**RE: Heading Segregation, File Number SEG-07-38**  
**Map Numbers: 18-20-20000-0006, 18-20-20000-0007**

Kittitas County Community Development Services has reviewed the proposed administrative segregation and hereby grants **final approval** to the referenced segregation application. Pursuant to Kittitas County Subdivision Code Chapter 16, please note the following items must be completed to complete the process.

SUBJECT: Heading SEG-07-38. 18-20-20000-0006, -0007.

CRUSE & ASSOCIATES
 PROFESSIONAL LAND SURVEYORS
 217 East Fourth Street Ellensburg, WA 98926 P.O. Box 959 (509) 962-8242
HEADING 300, LLC PROPERTY

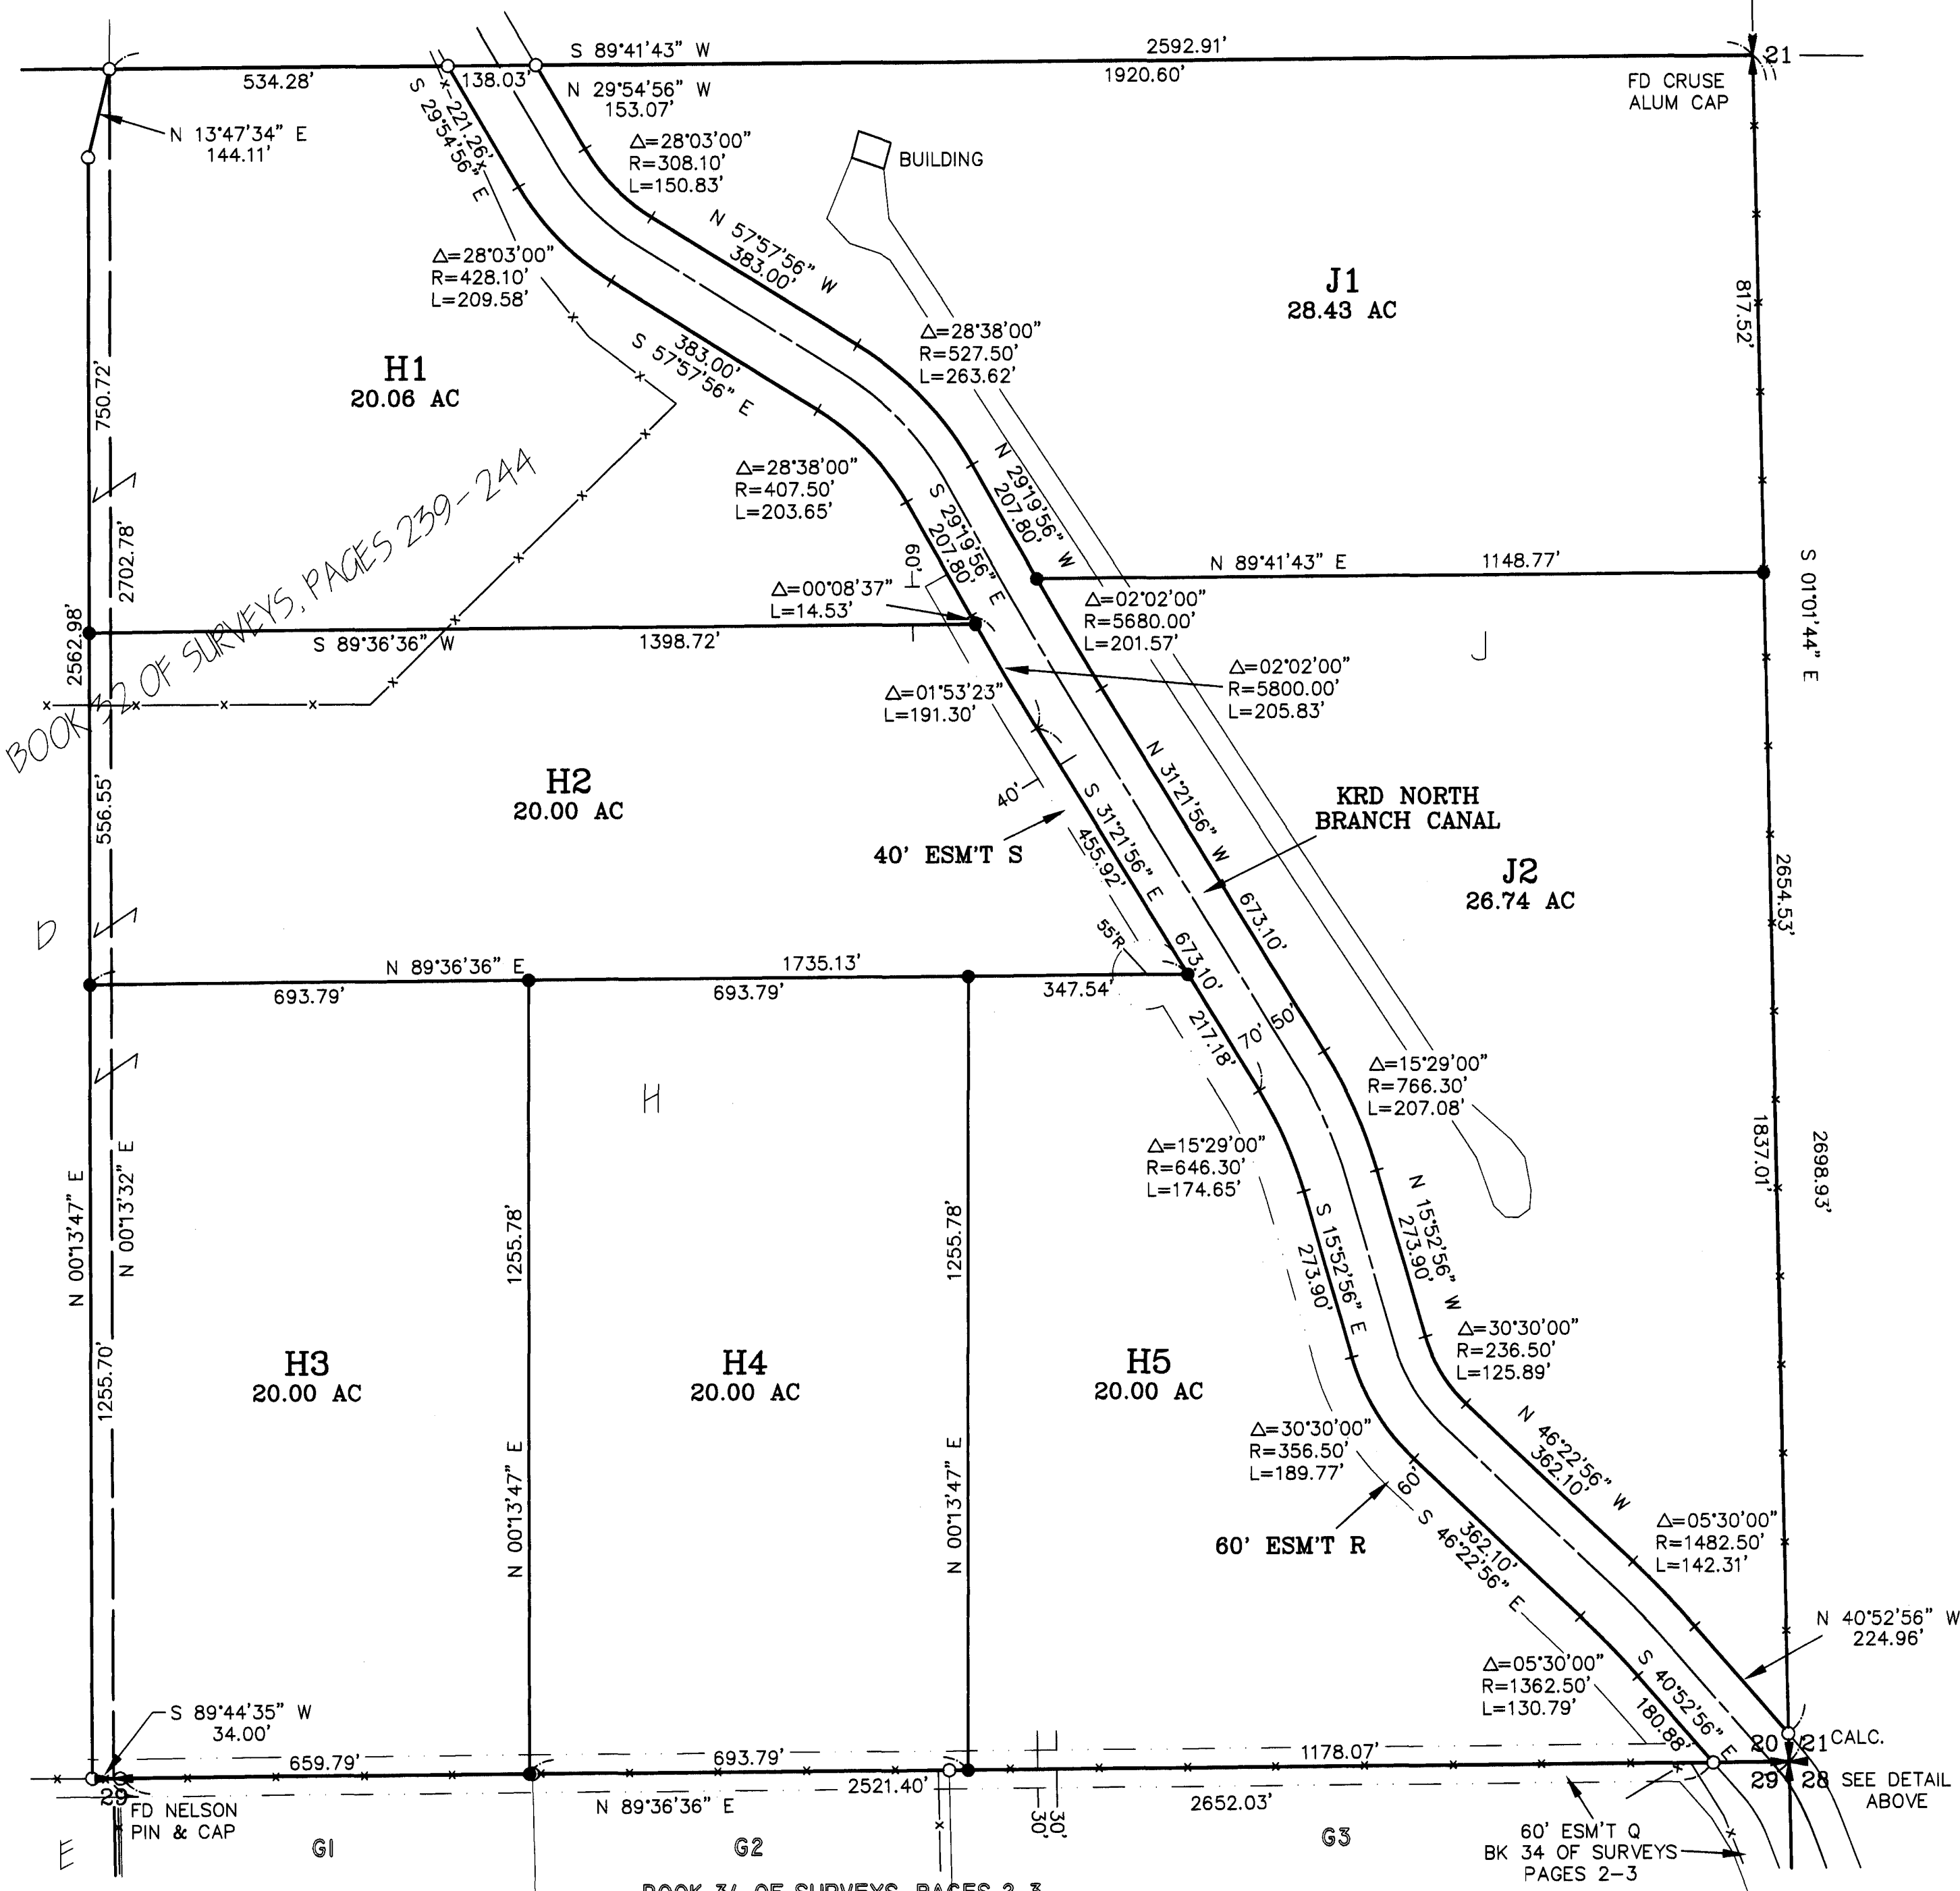
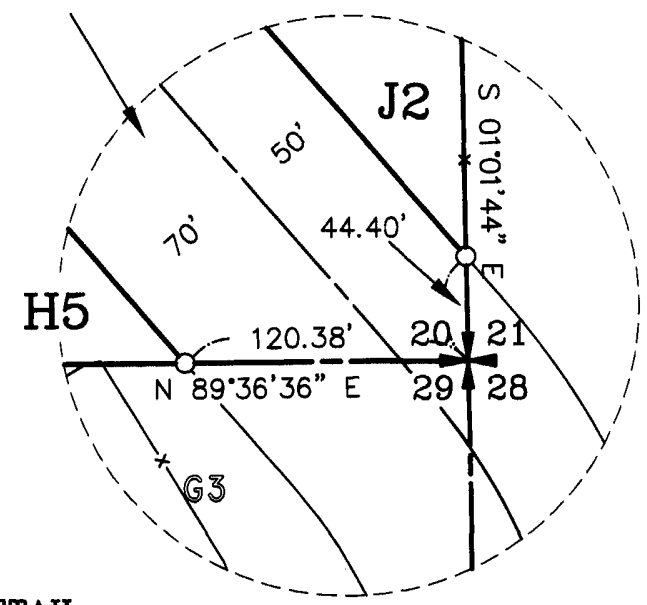
1. Lot J1 and J2 Access: The applicant has indicated that access to J1 and J2 will be from individual canal crossings. In the event that both lots are accessed from Easement 'S', the road will need to be extended and a turnaround constructed at the crossing point.

3. Private Road Improvements: Access shall be constructed as a Low-Density Private Road. See Kittitas County Road Standards, 9/6/05 edition.
  - a. Access easements shall be a minimum of 60' wide. The roadway shall have a minimum width of 20', with 1' shoulders, for a total width of 22'.

- b. Minimum centerline radius will be 60'.
  - c. The surface requirement is for a minimum gravel surface depth of 6".
  - d. Maximum grade is 12%.
  - e. Stopping site distance, reference AASHTO.

4. Cul-de-Sac: A cul-de-sac turn-around having an outside right-of-way easement diameter of at least 110 feet shall be constructed at the closed end of all dead-end roads serving 3 or more lots. The driving surface shall be at least 96 feet in diameter. Cul-de-sacs must also conform to the requirements specified by the 2006 International Fire Code. Contact the Fire Marshal regarding any additional cul-de-sac requirements.
